**Planning Application 6/2021/0079/FULL
8 Hill Rise, Cuffley EN6 4EE**

I write on behalf of Mr C Theodorou, the occupier of the neighbouring property at 6 Hill Rise, to raise objection to the above application seeking planning permission retrospectively for the erection of a dwelling (revisions to planning permission Ref 6/2018/0383/FULL).

Project Address	8 Hill Rise, Potters Bar, EN6 4EE
Sheet Title	As Built Site Plan
Sheet Number	A106
Paper Size	A1
Revision	
Issue Date	01/01/2021

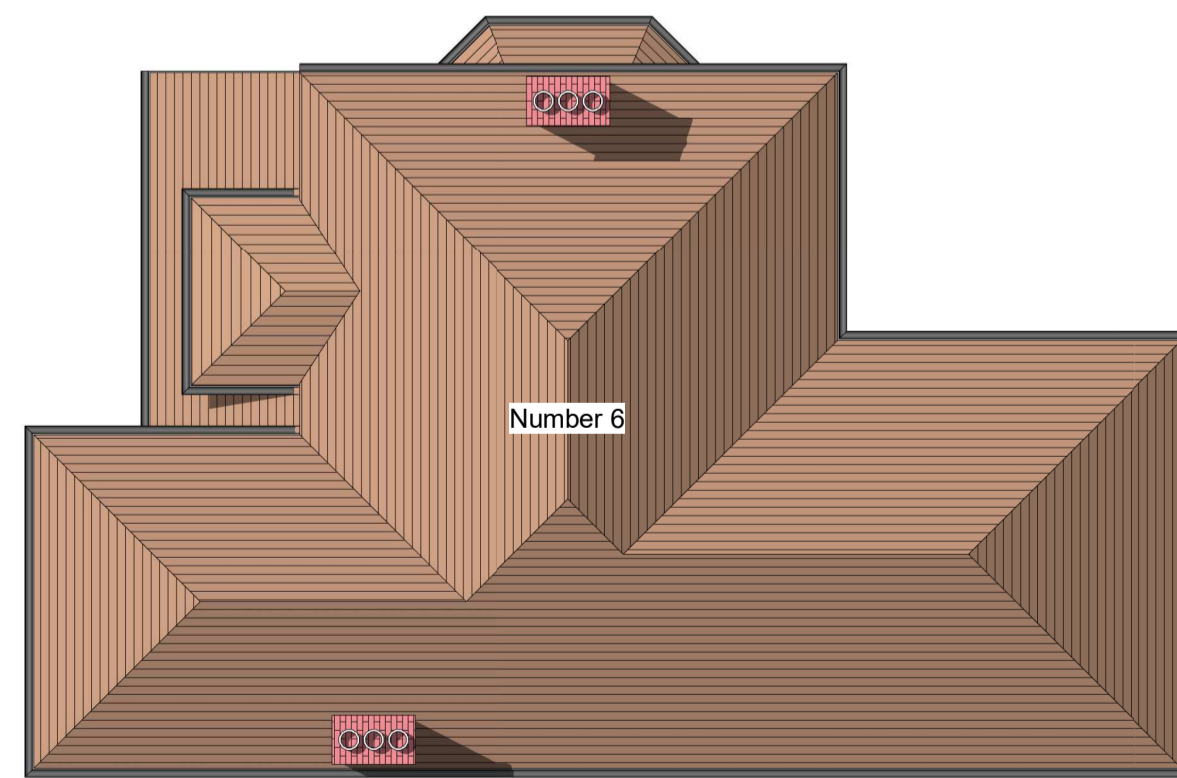
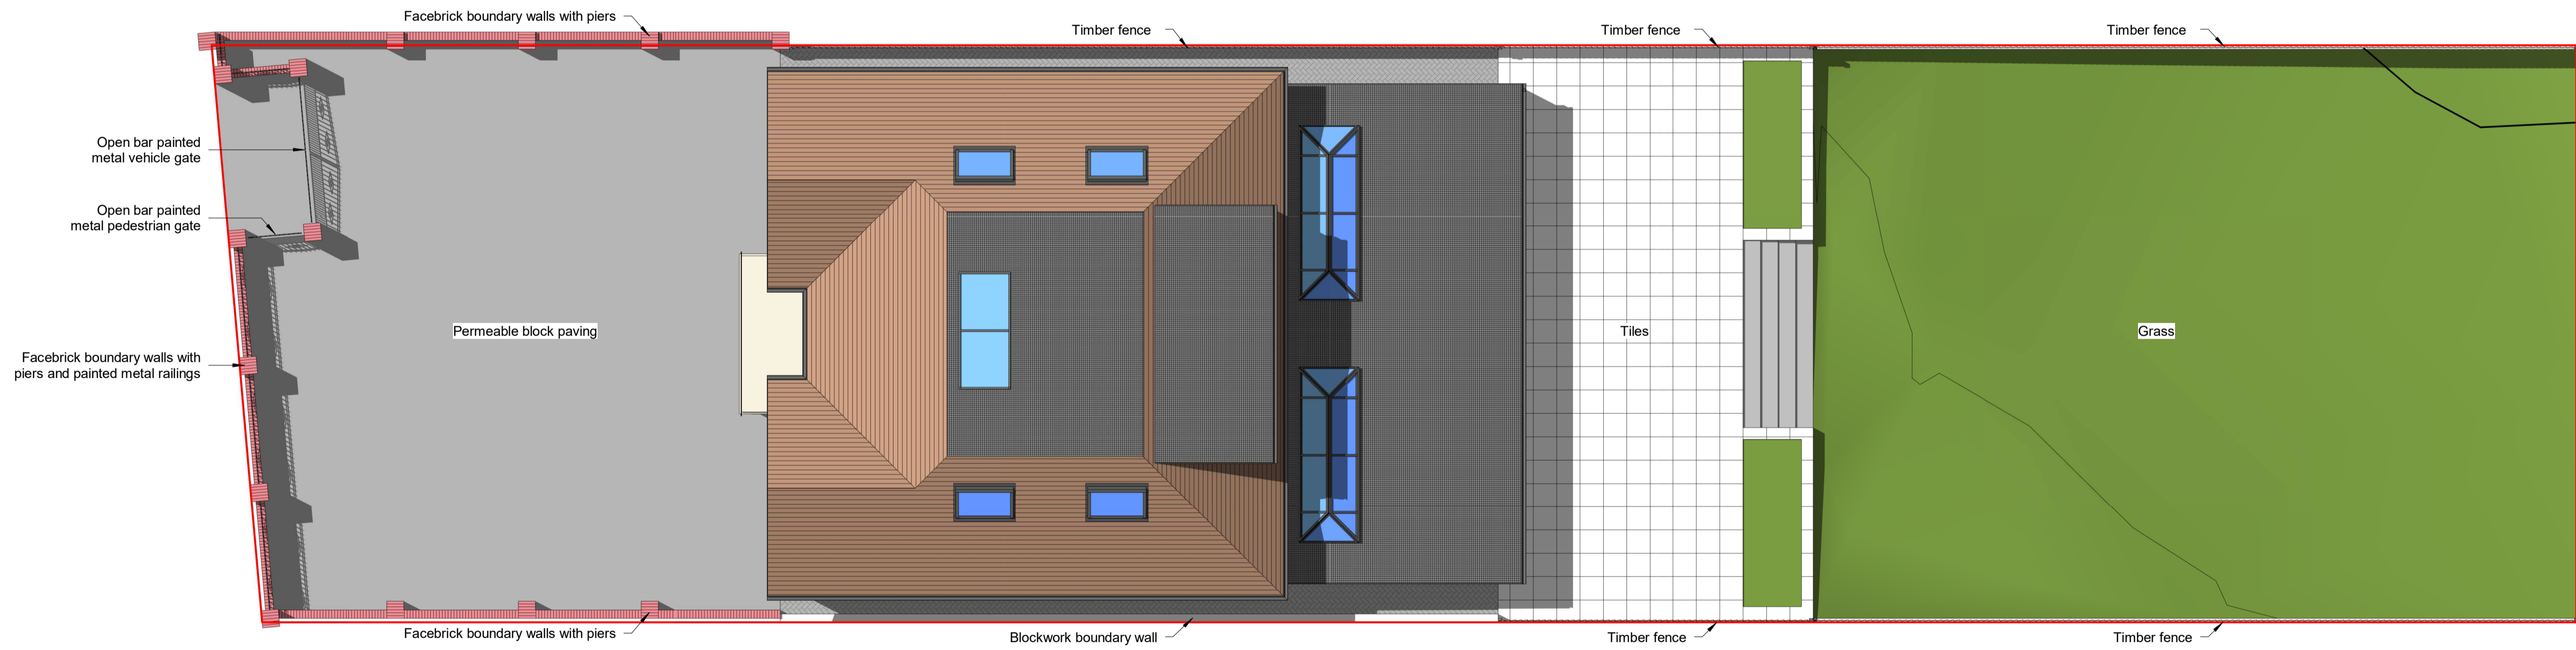
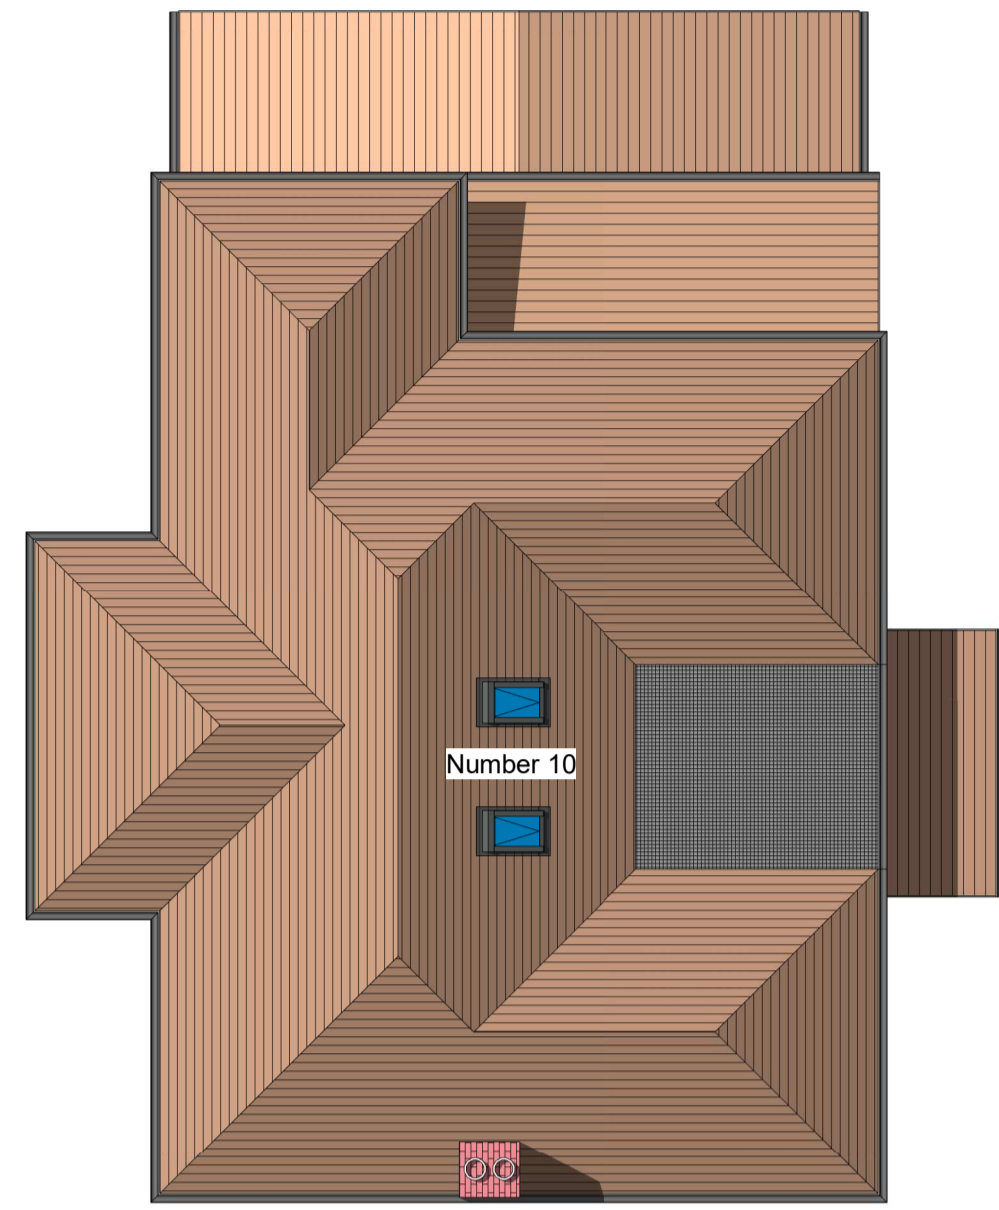
This new proposal severely affects my client's living conditions with regard to the proposed raised rear patio. As approved, this structure was of moderate size and, crucially, should have been built away from the common boundary, allowing for an alleyway running at ground level adjacent to the boundary fence. This would have afforded a much needed to degree of physical separation between the adjoining rear gardens.

However, as built, the raised patio extends over the alleyway right up to the boundary fence, thereby removing all physical separation and destroying

what privacy would have remained to my client's private rear garden space. It should be particularly noted that the elevated nature of the patio greatly increases the potential for intrusion. It is therefore critical, in our opinion, that the patio is set away from the common boundary in accordance with the approved plans.

As built, the raised rear patio affords direct views down onto my client's rear garden and towards the rear facing habitable room windows in the dwelling. Equally, users of the raised rear patio can be clearly seen from my client's rear garden, which is itself extremely intrusive within the context of what are supposed to be private rear gardens. The elevated nature of the patio, combined with its increased area and lack of physical separation to the site boundaries, increases the potential for noise and disturbance associated with the use of the patio.

We note that a similar degree of separation should likewise have been provided in relation to 10 Hill Rise. This not only erodes the privacy enjoyed by the occupiers of No 10 but also creates a serious hazard for the occupiers of No 8, owing to the fall of the land and the steep drop to this side of the patio. This problem is compounded by the failure of the applicant to provide a barrier to the side of the patio, as shown on the approved plans, which would at least have afforded users of the patio with a degree of protection.

It should be further noted that the new retaining wall adjacent to my client's property is almost 2m high and far more substantial than that shown on the approved plans. This is both unsightly, as it results in an incongruous and obtrusive landscape feature, and potentially very dangerous insofar as it creates a significant unexpected drop in levels. Whilst not strictly a planning matter, you will also note that the retaining wall is leaning, which indicates it has not been properly constructed and, in its current form, presumably fails to comply with the relevant requirements under the Building Regulations.

The same problem applies to the retaining wall between Nos 8 and 10, which suffers from a 2.5m high drop, and is also in breach of planning control as the safety barrier shown on the approved plan has not been installed.

Project Name and Address
ELEVATIONS
8 HILL RISE
CUFFLEY
UNITED KINGDOM

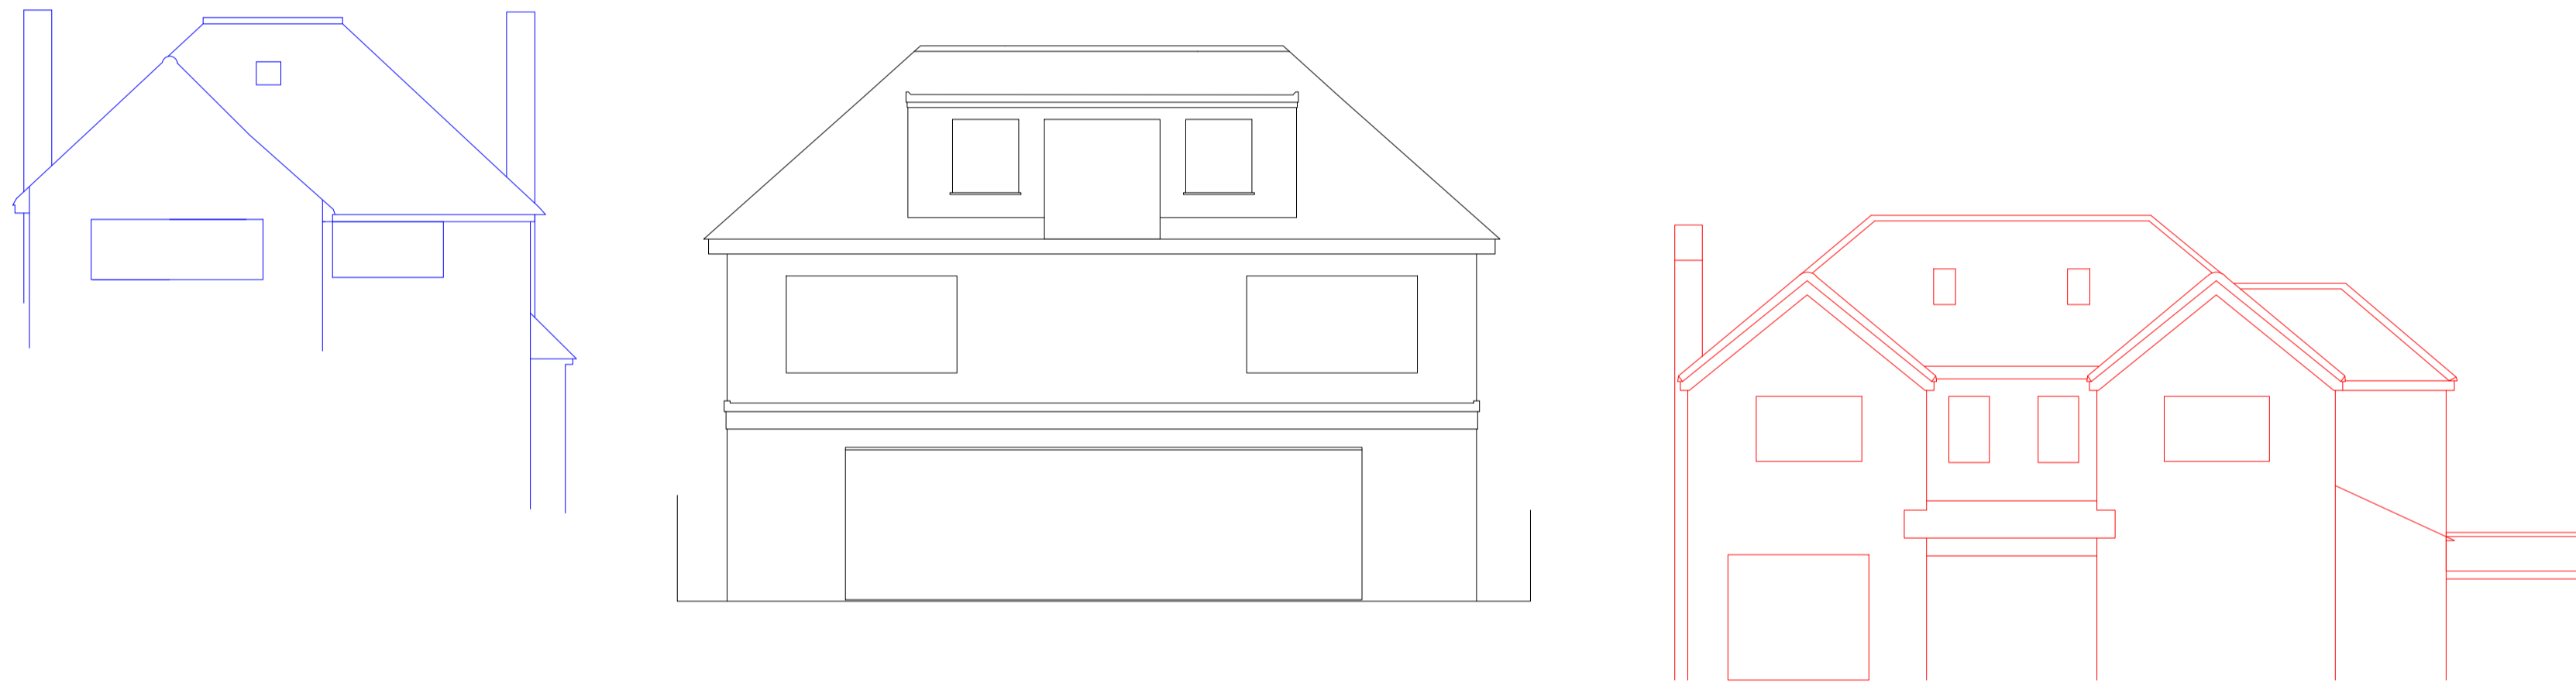
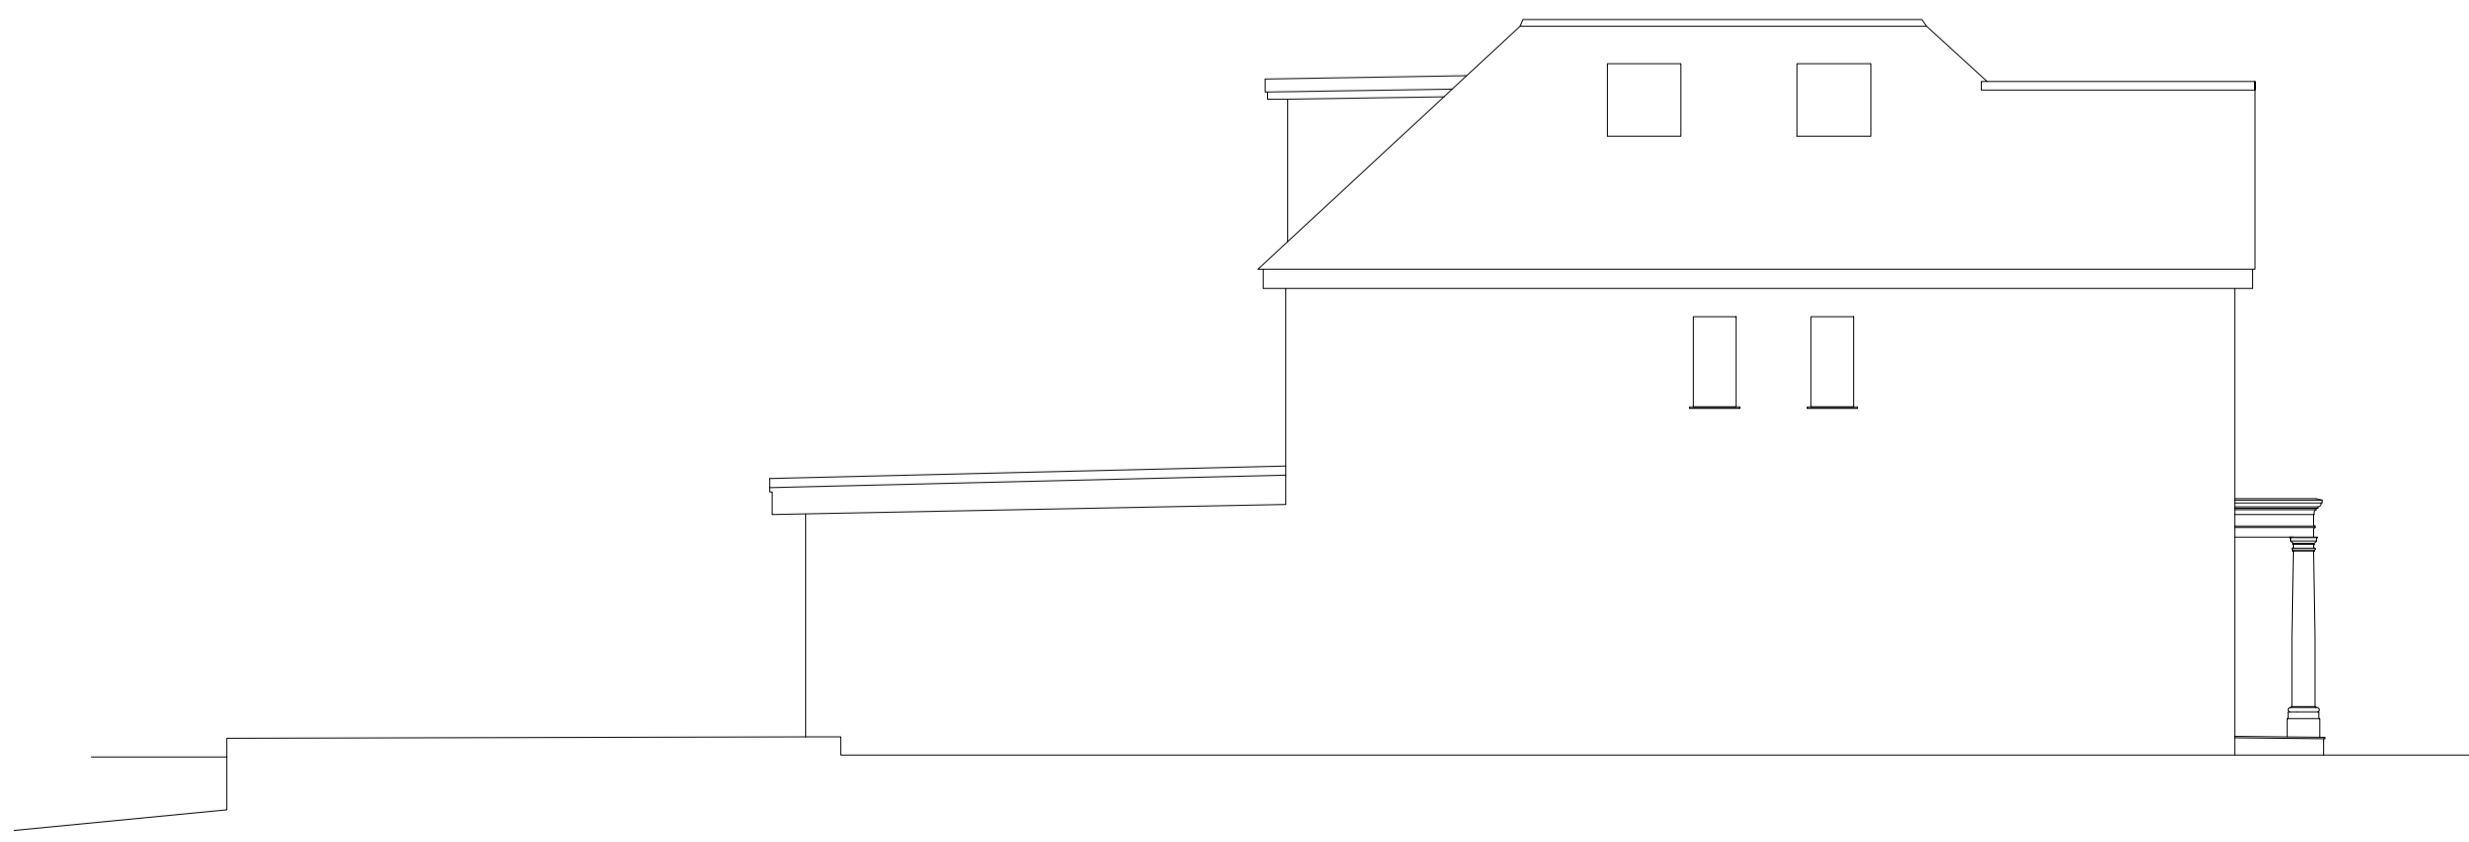
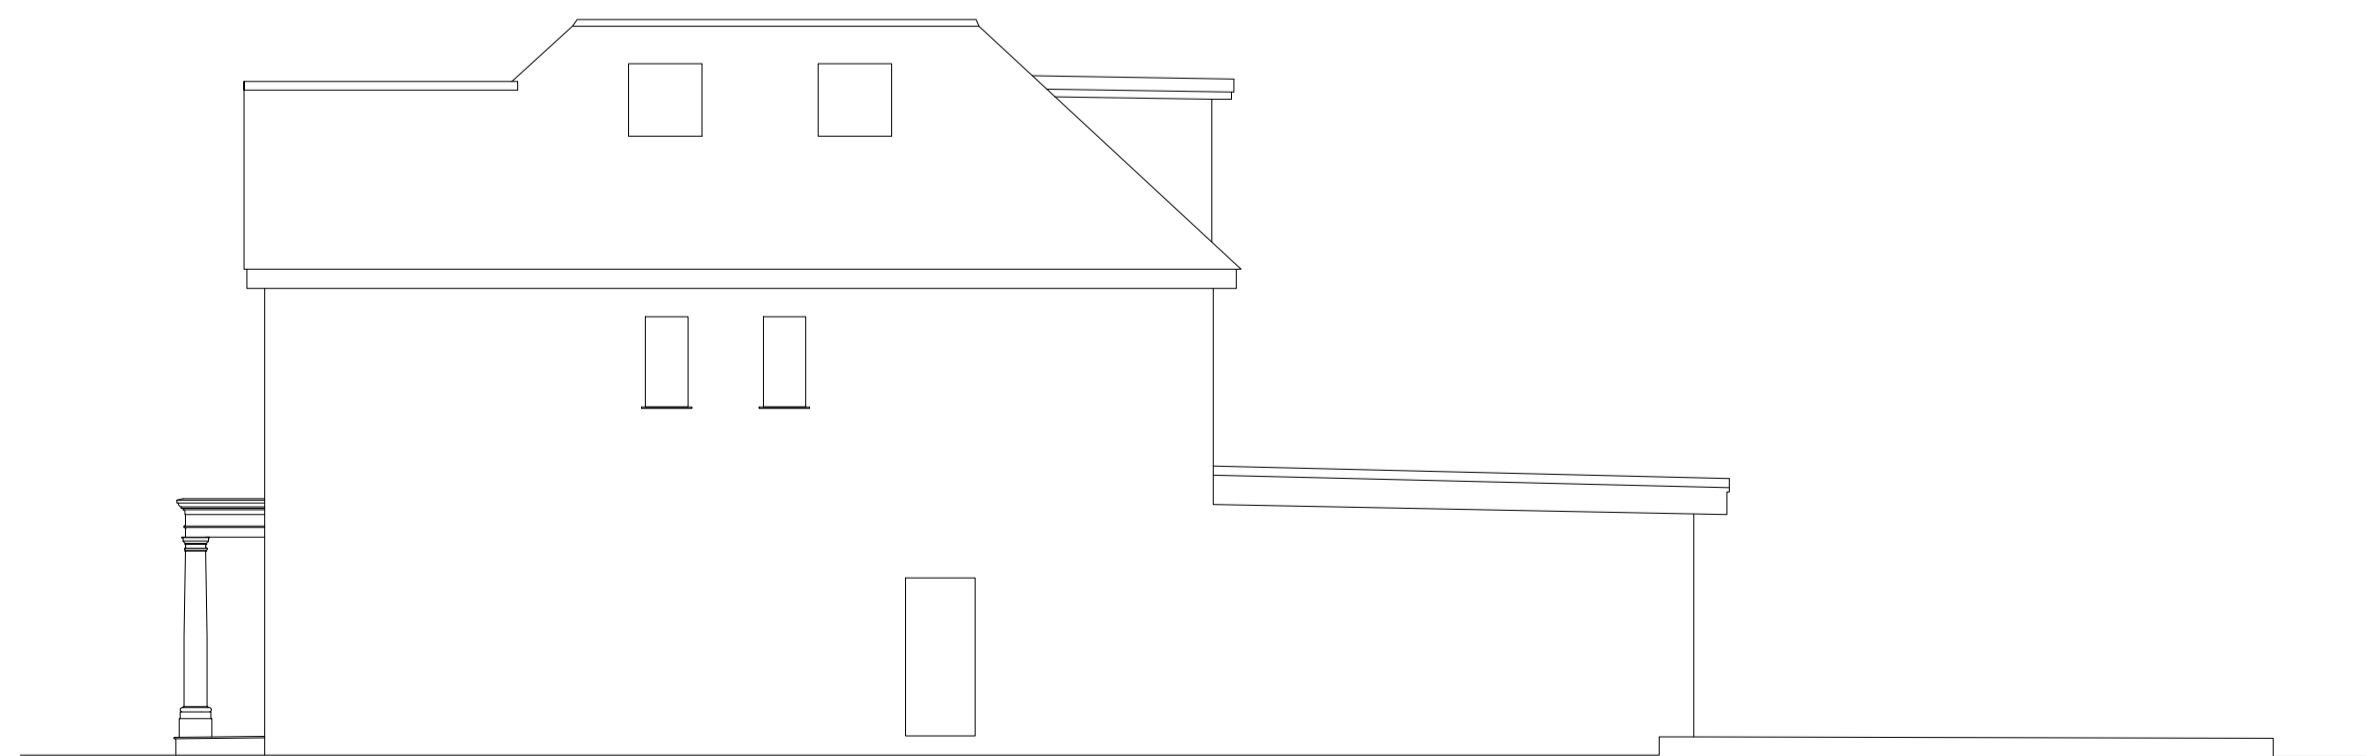
Turning to the house itself, you will note that the new dwelling at No 8 has been built out to a significantly higher ridge level than approved. As a consequence of this, the ridgeline no longer steps down in height to follow the fall of the land, thereby disrupting the stepped roofline that is an important feature of the street scene. This is highly undesirable in urban design terms, as it interrupts the pleasing sense of balance that currently exists between the dwellings, whereby the dwellings step down the slope

proportionately. Instead, the dwelling at No 8 appears disproportionately tall and unduly prominent and obtrusive in the street scene. The additional bulk and massing of the development only adds to the impression of overdevelopment to the detriment of local character.
